From: Amanda Scholes on behalf of Planning.Responses
Sent: 17 October 2019 09:02
To: Planning Scanning
Subject: FW: EP/179/18/PL

From: Juan Baeza [REDACTED]
Sent: 16 October 2019 12:51
To: Planning.Responses [REDACTED]
Subject: EP/179/18/PL

From: PETER SHAW [REDACTED]
Sent: 16 October 2019 12:12
To: Juan Baeza [REDACTED]
Subject: Re: Gladwyn - East Preston

Further to this morning's meeting at Gladwyn, The Street, East Preston, I can confirm that I am satisfied with the proposed parking provision of 9 spaces as per revised plan provided by Mr Shaw on Friday (11th October).

Project: Proposed new homes; Gladwyn, The Street, East Preston BN16 1HT			
Drawing: Block plan			
FOR: Mrs. J. Simmonds & Mr. P. Beamish			
Drawn: PKS	Date: November 2018		
Scales: 1:200	No: 2386/01/03/A		
To scale when printed on A3

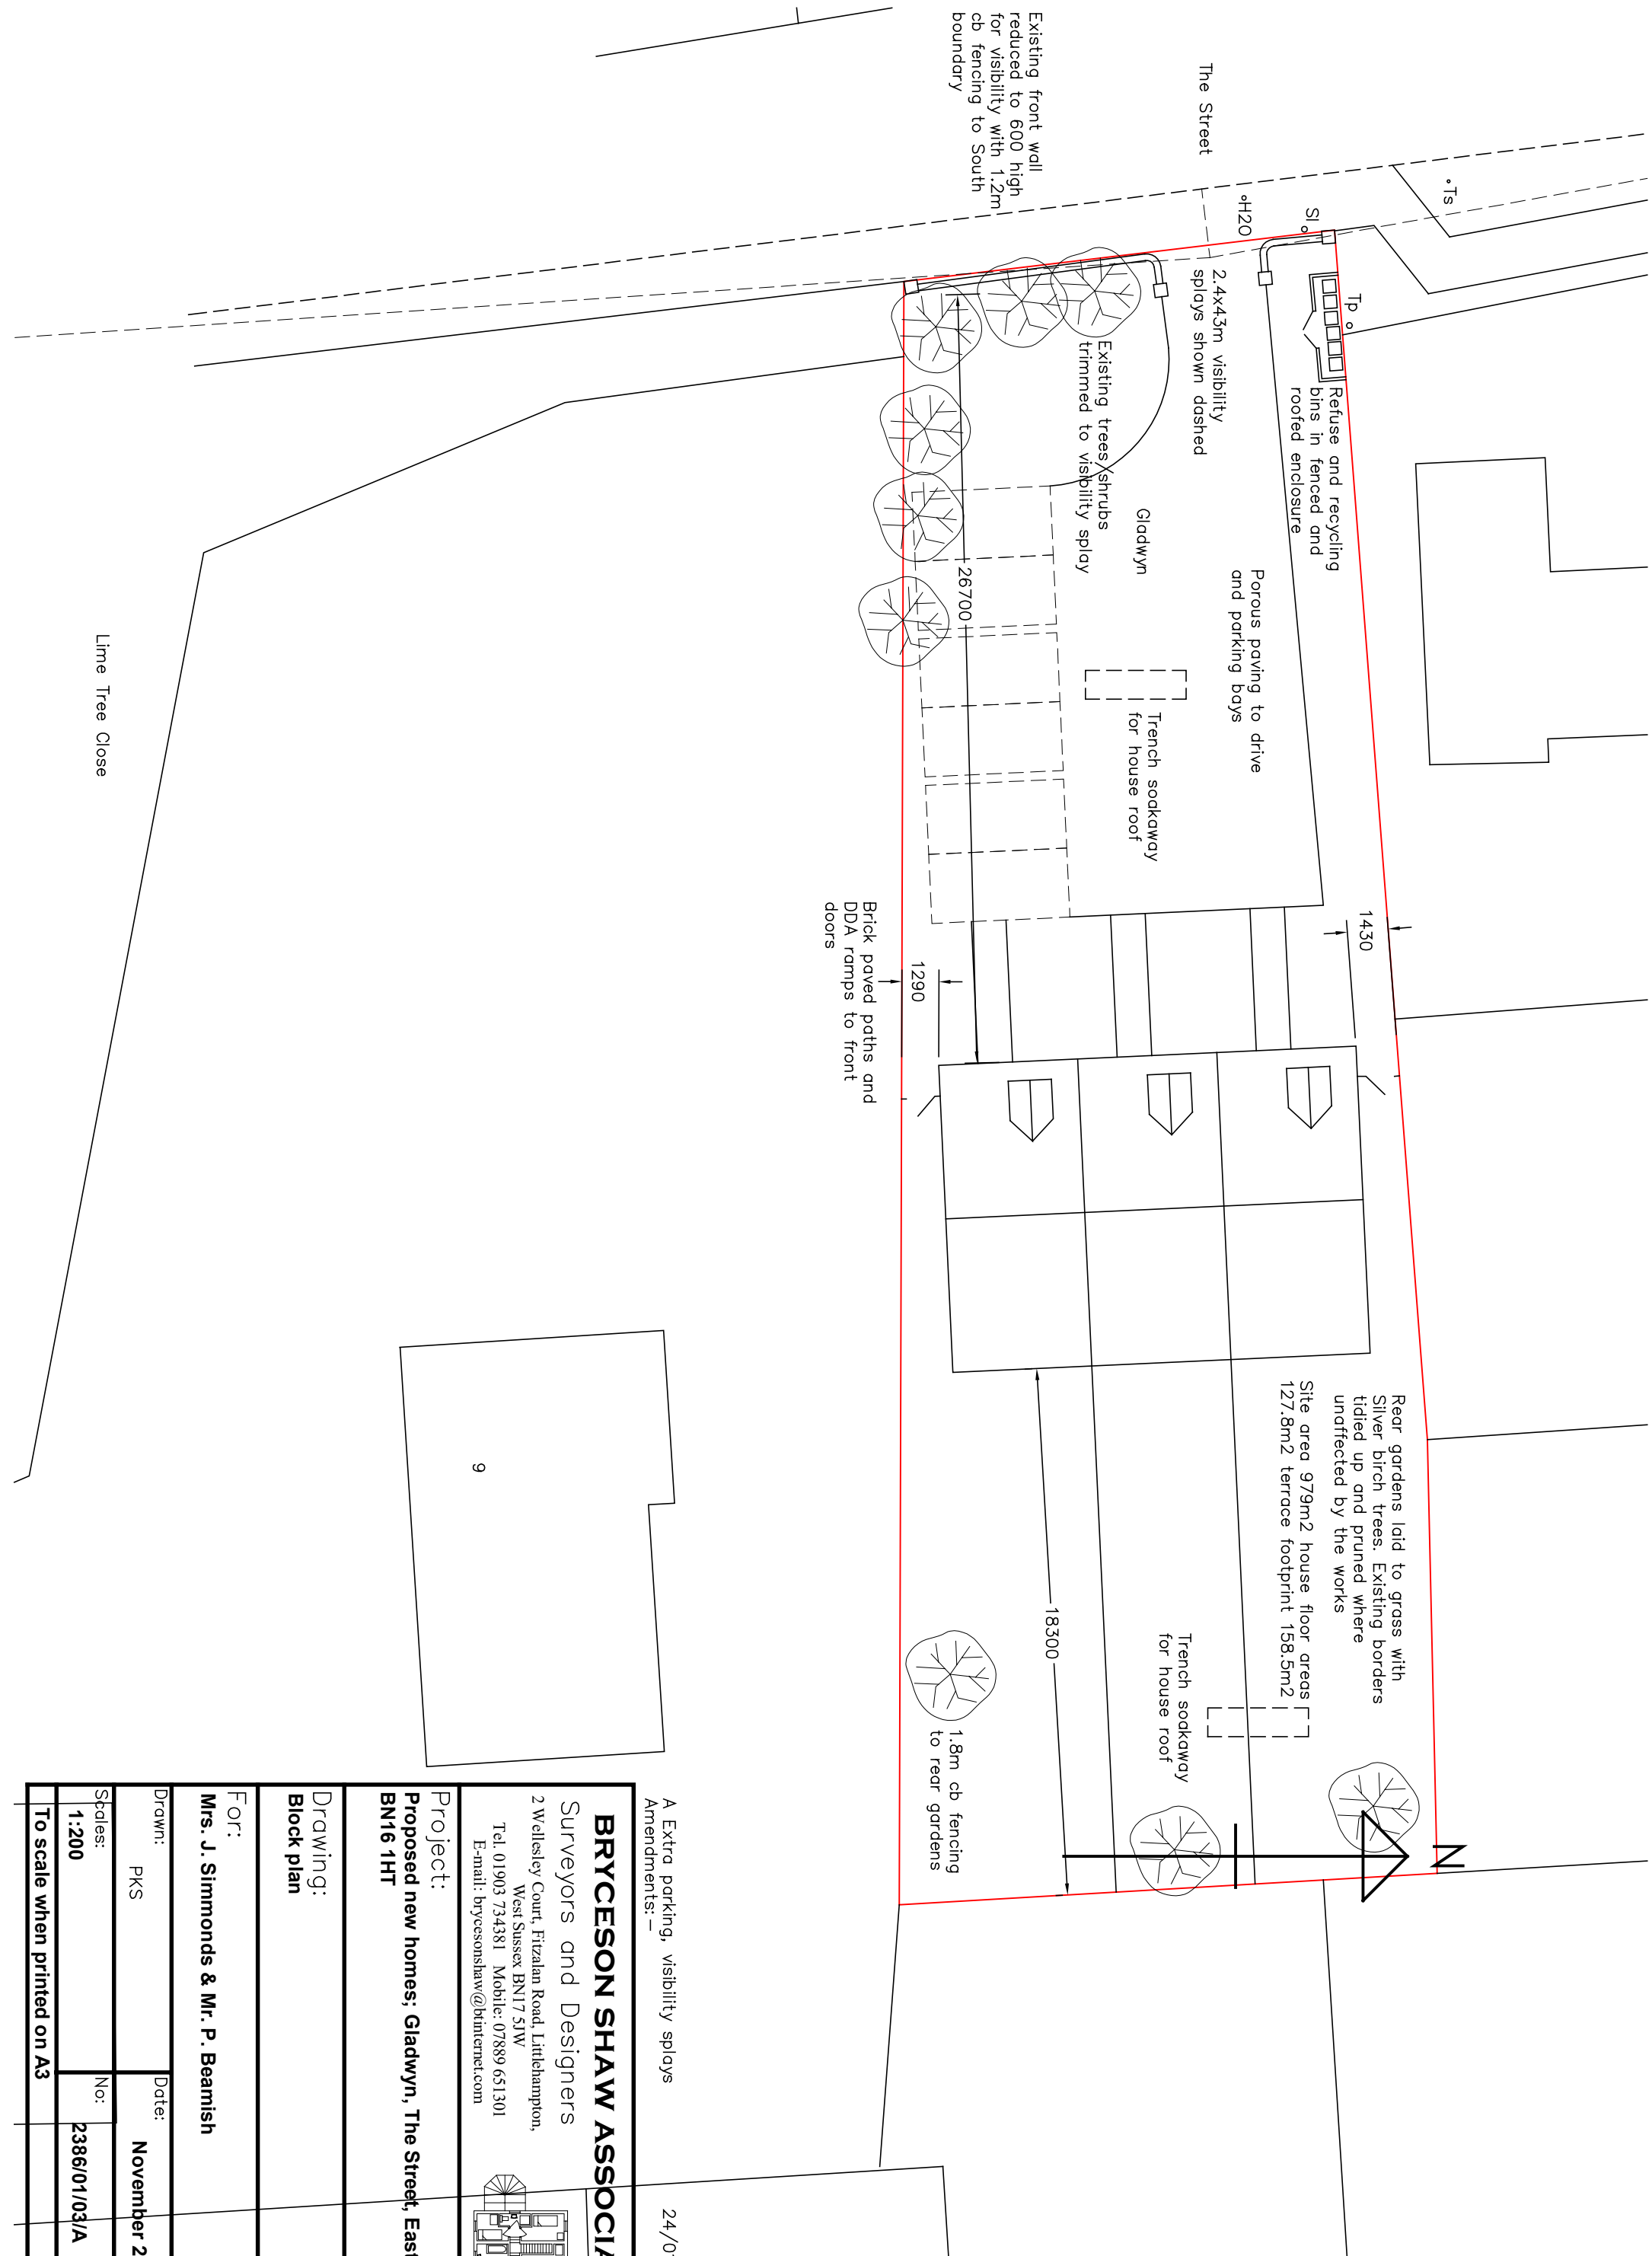
I can confirm that 9 spaces meets the minimum requirements for allocated parking provision, i.e. 2 spaces allocated per dwelling and 3 overspill/visitor parking spaces. I understood from Mr Shaw that he intends to retain unallocated provision, in which case, the proposed provision exceeds the minimum requirement of 7 unallocated spaces.

In the meantime if you could copy us all into a suggested amended plan designed to increase internal parking and moving the flint wall into the site would be appreciated prior to Tuesday.

Project: Proposed new homes; Gladwyn, The Street, East Preston BN16 1HT			
Drawing: Block plan, bin store elevations			
For: Mrs. J. Simmonds & Mr. P. Beamish			
Drawn: PKS		Date: November 2018	
Scales: 1:50 1:200		No: 2386/01/03/C	
To scale when printed on A3

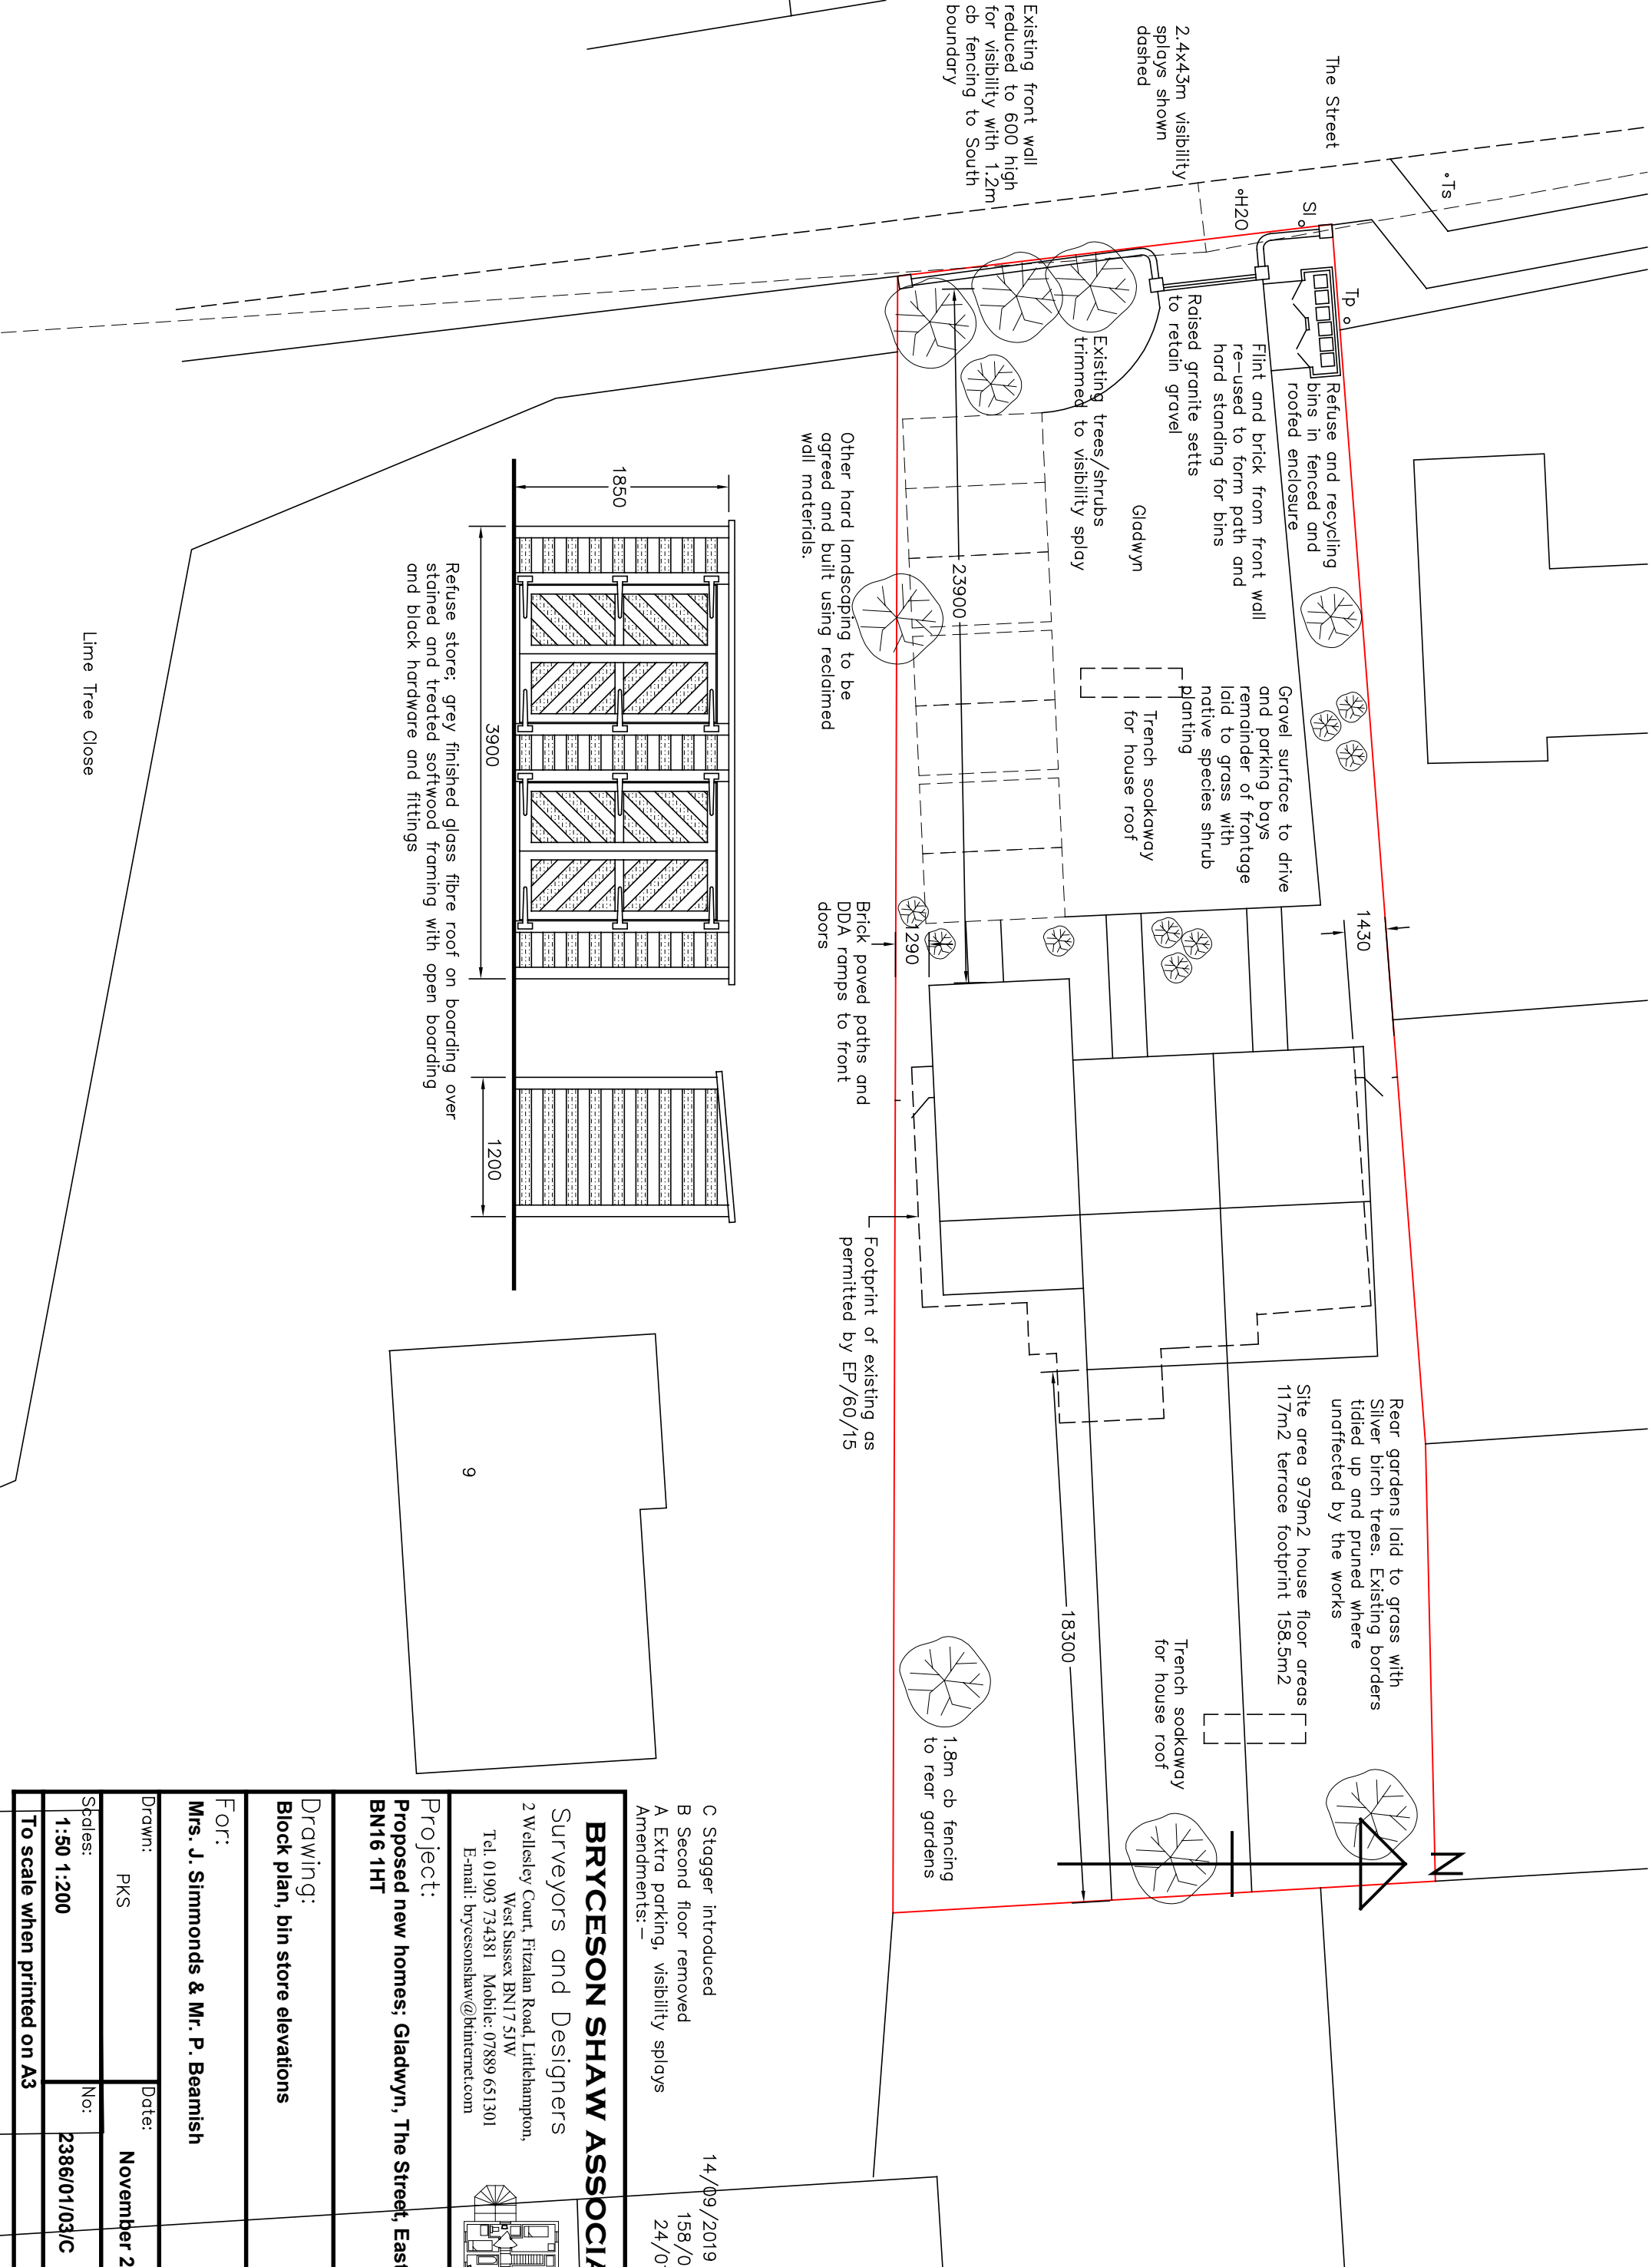
With regards to the boundary wall, we measured visibility on site at a distance of 2.4m back from the carriageway edge. In the leading direction (to the north of the access) 43m visibility is achievable in accordance with Manual for Streets (MfS) standards, without any alterations to the existing wall required. In the trailing direction (to the south), visibility is obstructed by the wall and overgrown hedges.

The current height of the boundary wall is 1.2m. We discussed two options on site, firstly the reduction in height of the wall, and secondly relocating the wall within the site. In its current position, due to the proximity to the school, we would require the wall to be reduced in height to 600mm to allow visibility of small children. However, we did agree on site that a compromise could be reached and we would support the wall being reduced in height to 800mm. This option would still result in some loss of the wall. We then discussed the option of repositioning the wall to a set-back of 0.5m from its current position. It was agreed by all that this would be the favoured option as it is anticipated to provide a full unobstructed visibility splay of 43m to the south and would not result in any loss of the flint wall.

Subject to a revised plan confirming that a 0.5m set-back would provide the required 43m splay to the south, I would not consider that this proposal would have an unacceptable impact on highway safety or result in 'severe' cumulative impacts on the operation of the highway network, therefore is not contrary to the National Planning Policy Framework (paragraph 109), and that there are no transport grounds to resist the proposal.

As discussed on site, I would request that a condition securing visibility splays (details to be provided) is applied.

- The highway officer visiting the site
- Increasing the number of on site car parking spaces
- Providing visibility splays without demolition of front boundary flint wall
- Whether county highway advice was arrived at taking into account appeal decision to allow neighbouring development reference EP/52/18/PL

Thank you for the meeting today and for your help. Please see the attached revised drawing showing the garden wall rebuilt some 500mm into the garden.

I would like to retain the Southern most brick pier as it defines the 2 boundaries of the plot and should not affect visibility. The final decision on this can be made once we start site clearance and can properly set things out.

I have plotted the drawing on A2 paper so the extent of the visibility splays is clear.
